Your ref:
Our ref: 22/02264/F
Please ask for: Miss Joanne Wren
Direct dial: 01553 616233
E-mail: borough.planning@west-norfolk.gov.uk

Details: **Single store and 2 storey extensions to dwelling, construction of car port at Church View Church Road Hilgay Norfolk PE38 0JL**

DRG. NO.:- 1717.2

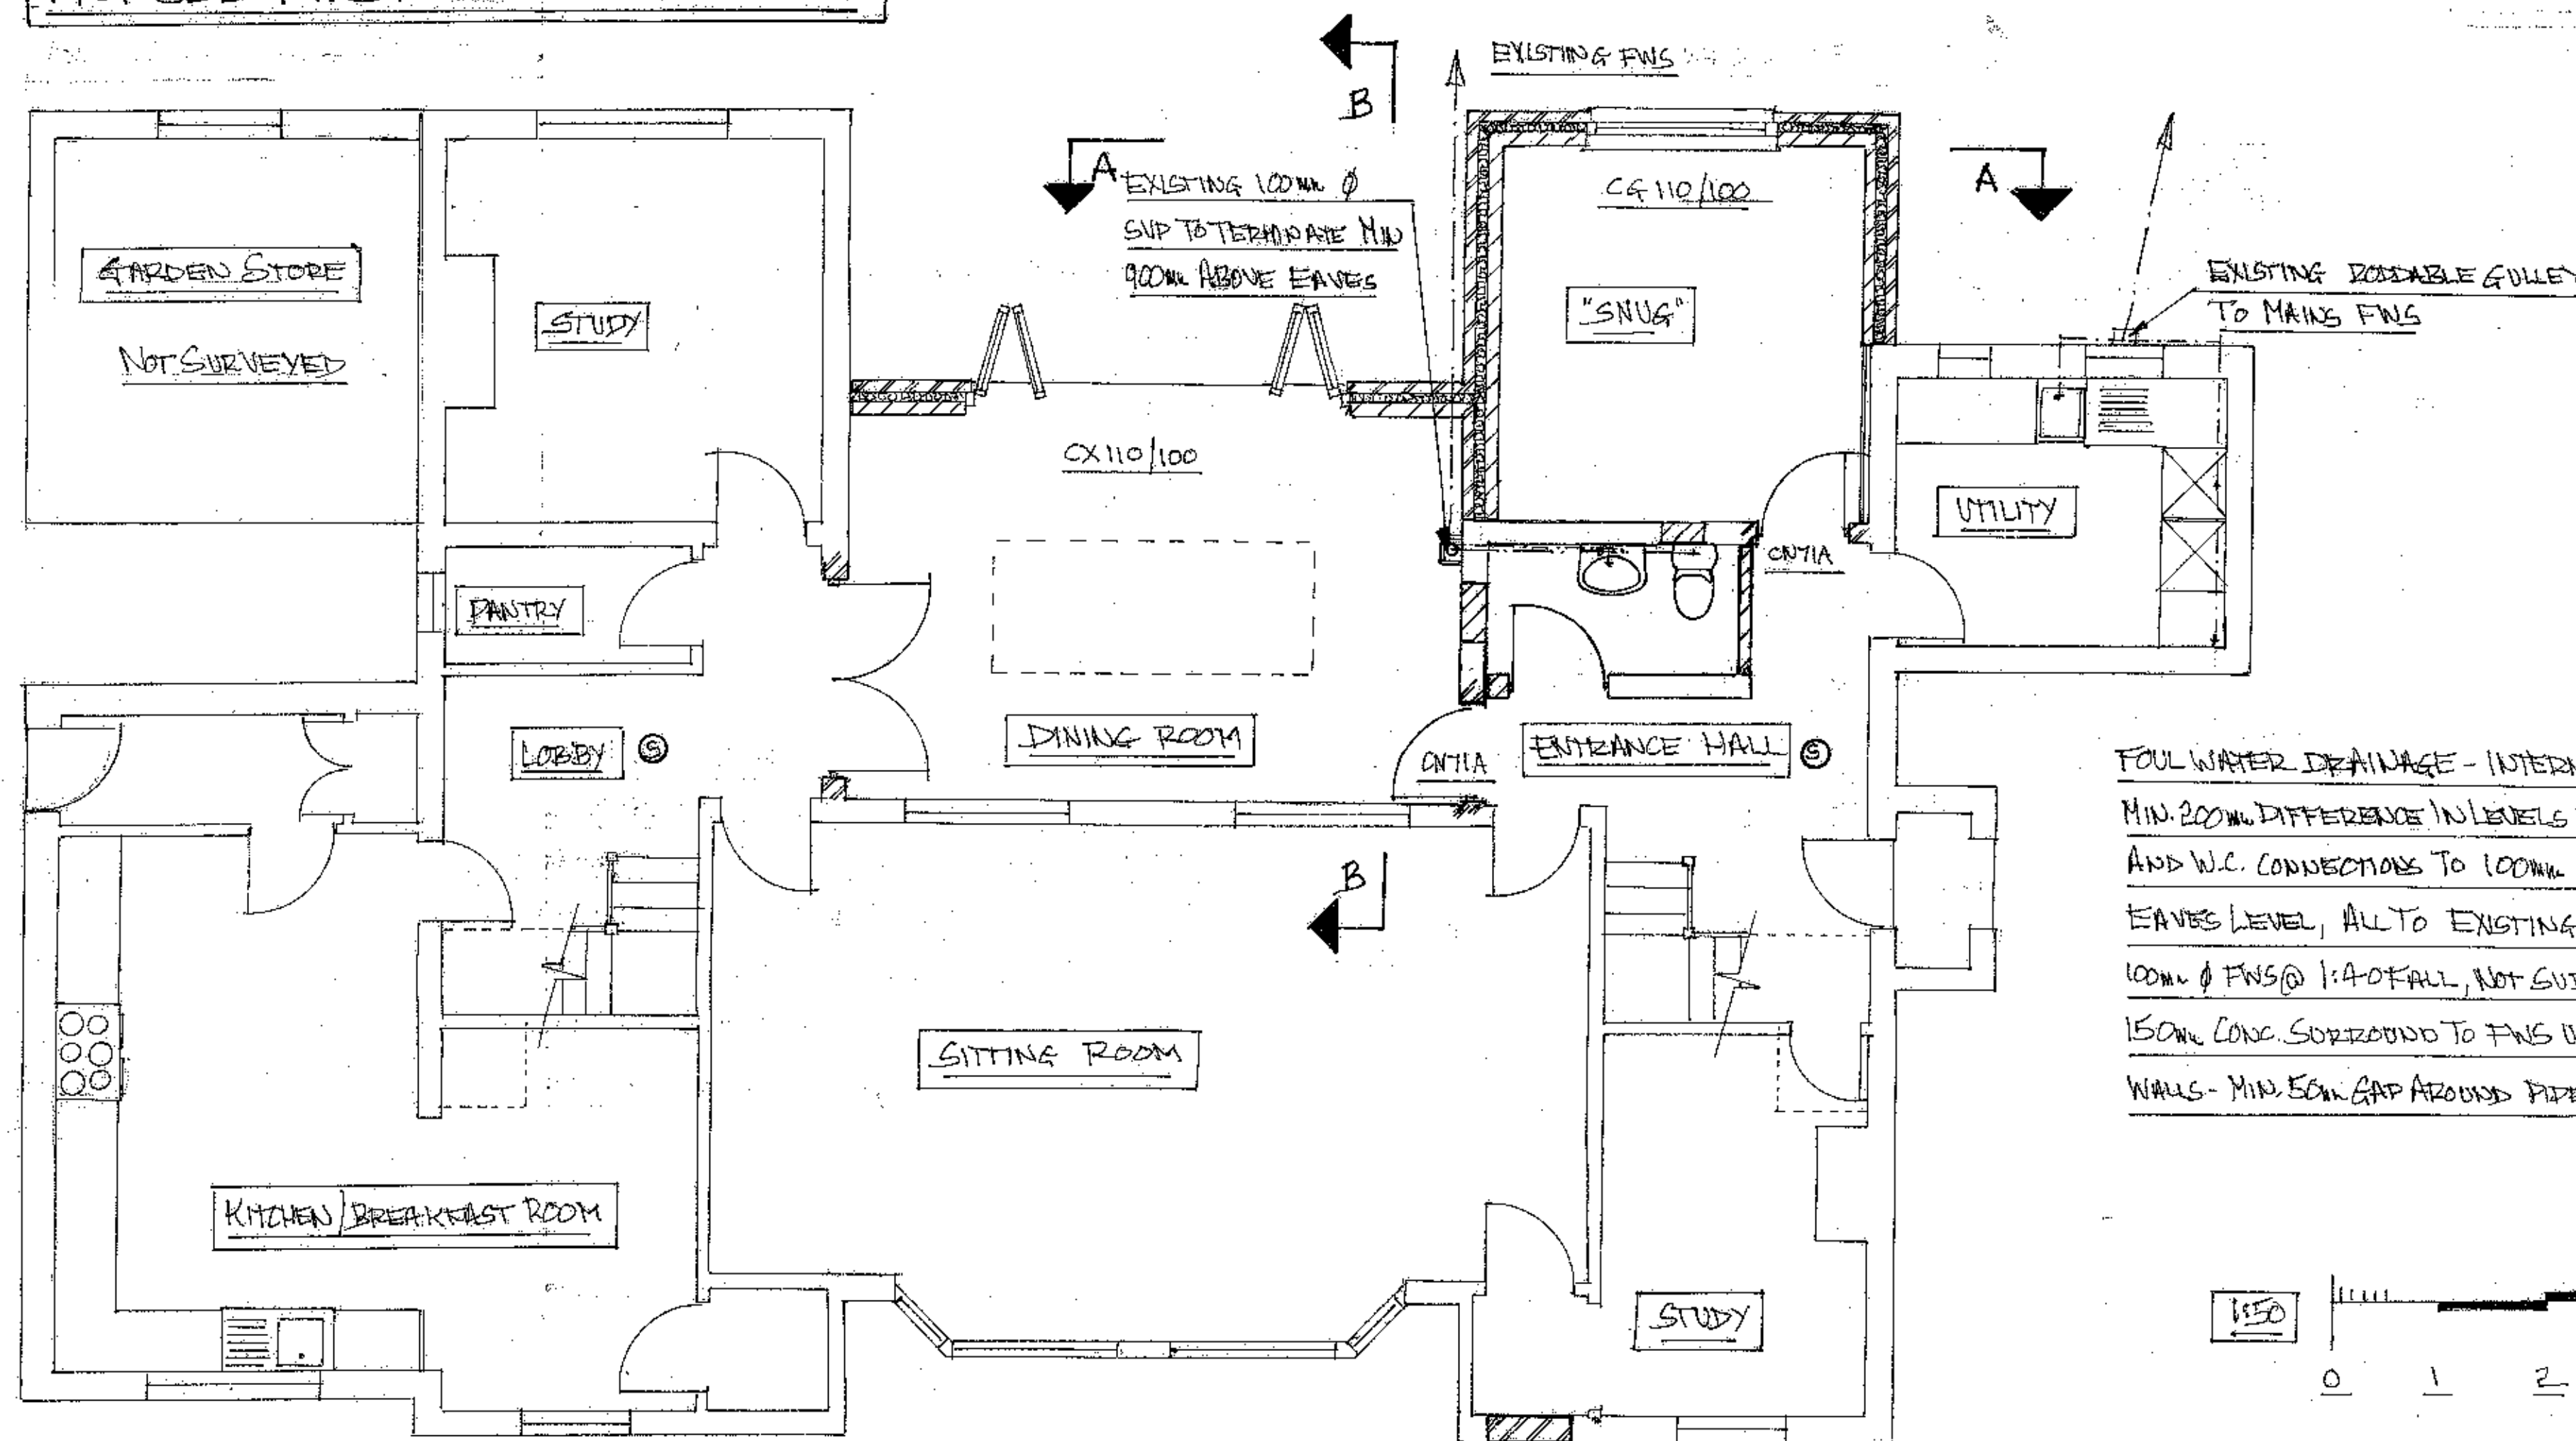
1. There is a window shown on the north elevation that is not on the floor plans. Please amend and resubmit these.
